This document is submitted to the Department of Planning, Housing and Infrastructure (DPHI) in support of the Response to Submissions (RTS) to the State Significant Development Application (SSDA) (SSD-94006708) for a mixed use development at 15-21 Cottonwood Crescent, Macquarie Park.

The Proponent has received feedback from the Department of Planning, Housing and Infrastructure (**DPHI**), Transport for NSW (**TfNSW**) and City of Ryde Council (**Council**), following the submission of the transport impact assessment report as part of the EIS submission. The responses are identified and references are provided to show where they are addressed in this document.

Appendix A: Vehicle Swept Paths

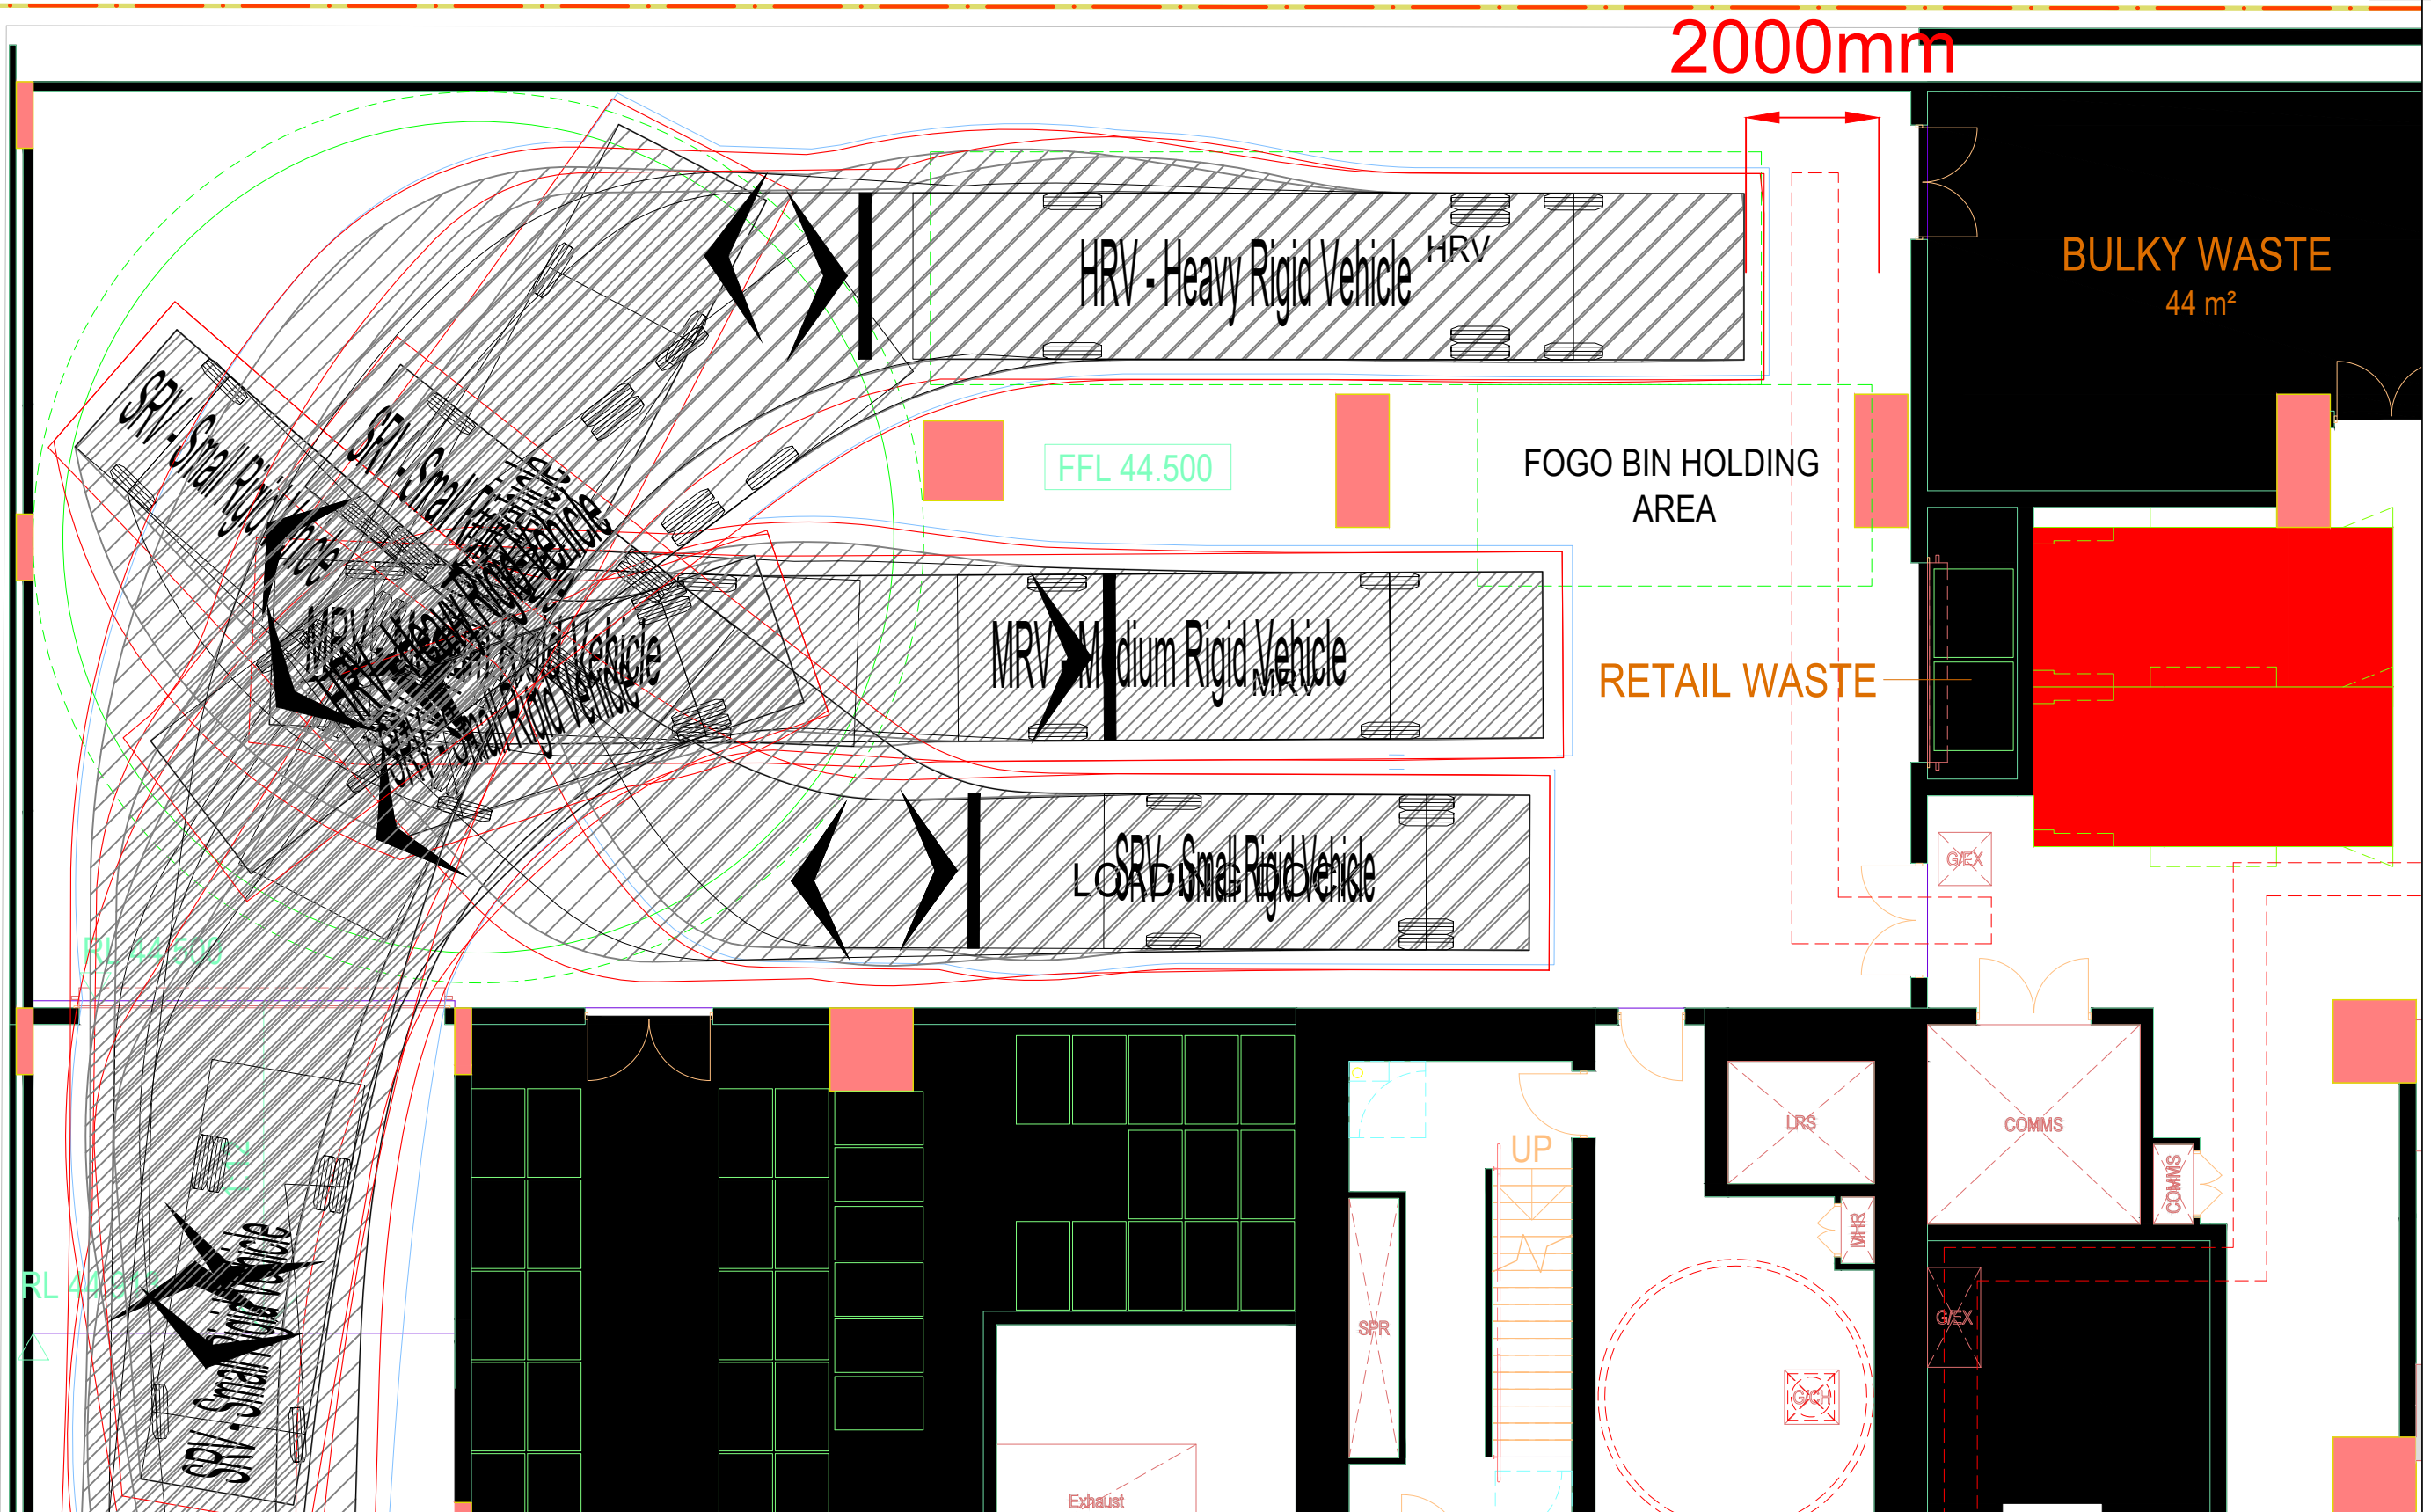
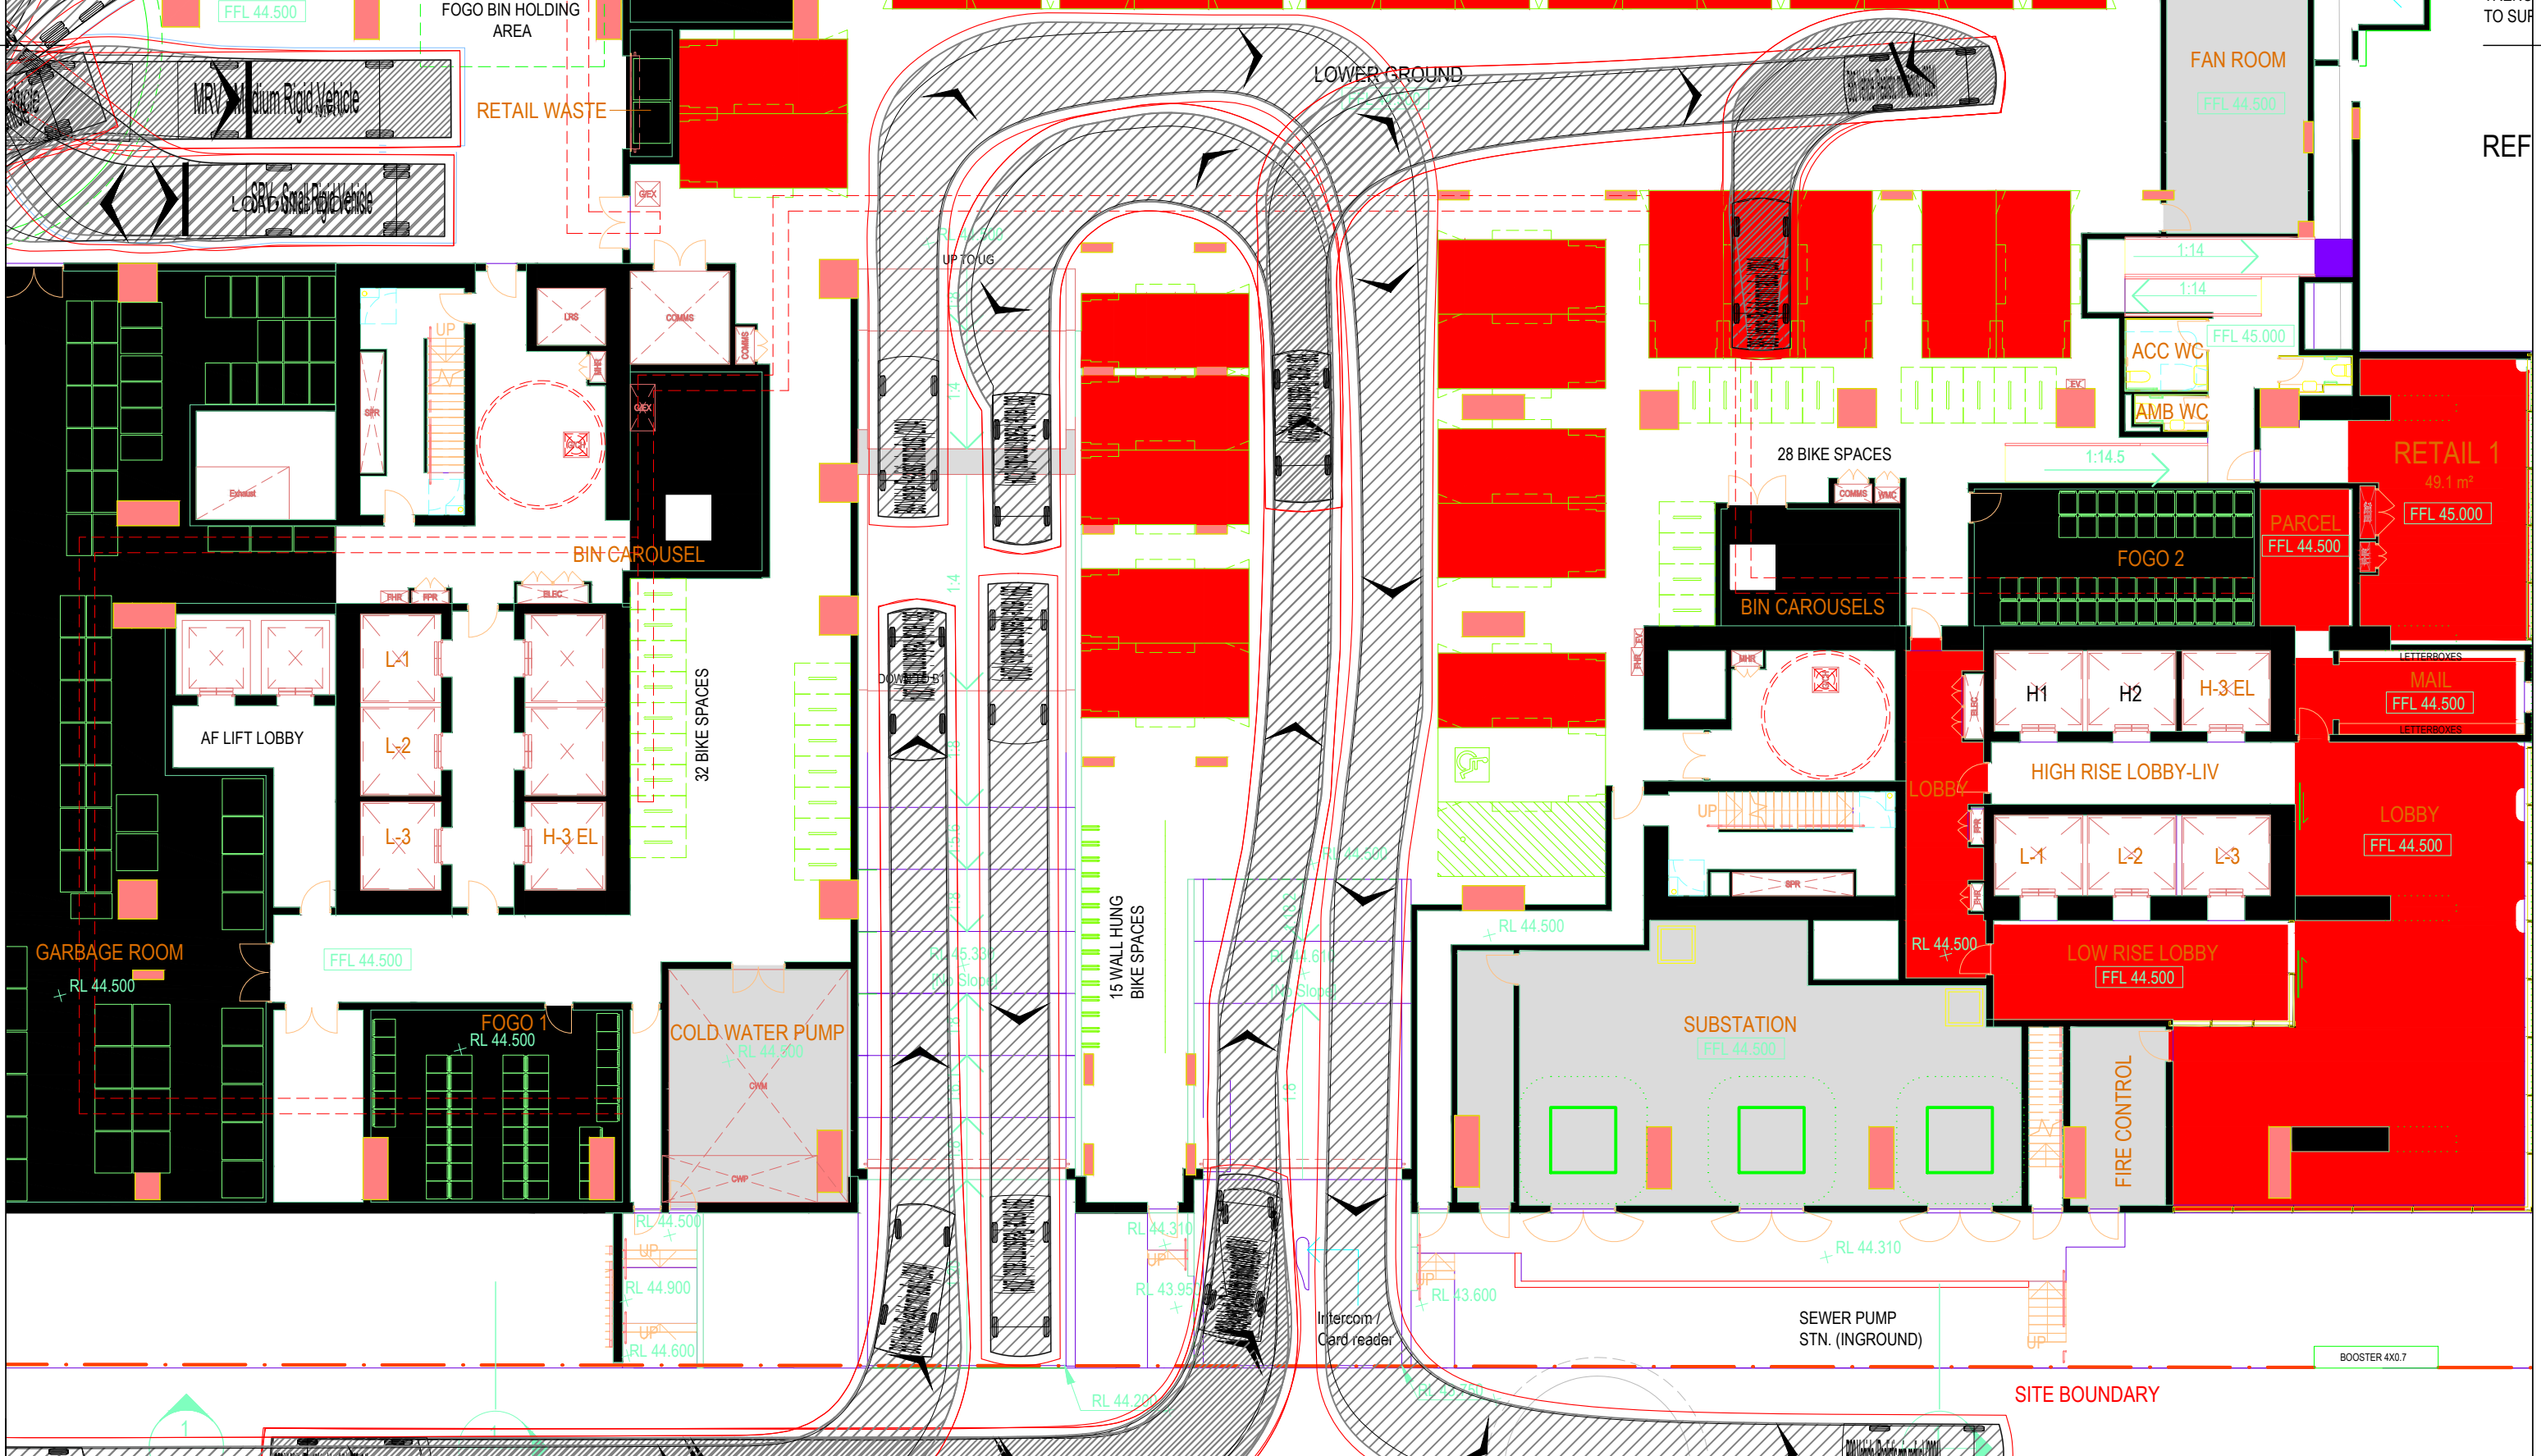
Agency	Agency Comment	JMT Consulting Response
Council – Waste Management	Provide swept paths for a heavy rigid vehicle in accordance with AS 2890.02 to ensure waste collection vehicles can safely access the site for servicing. - The swept paths provided cannot be used to clearly identify the proposed transit of the 12.5 metre HRV utilised for waste collection. Swept paths must be clearly identified for each vehicle type. - The paths detailed in the Traffic Impact Assessment do not clearly show the vehicle body therefore conflicts cannot be determined. - The provided swept paths do not clearly demonstrate whether the proposed turntable is unobstructed from bins doors, or support structures. This space must remain clear of all obstructions to support safe and efficient servicing.	Full scale swept path plans are provided in Appendix A of this document, including for a 12.5m HRV utilised for waste collection. The swept paths include both the vehicle body and clearance envelope as required under AS2890.2. The swept paths confirm that the proposed turntable is unobstructed from bins doors, or support structures.
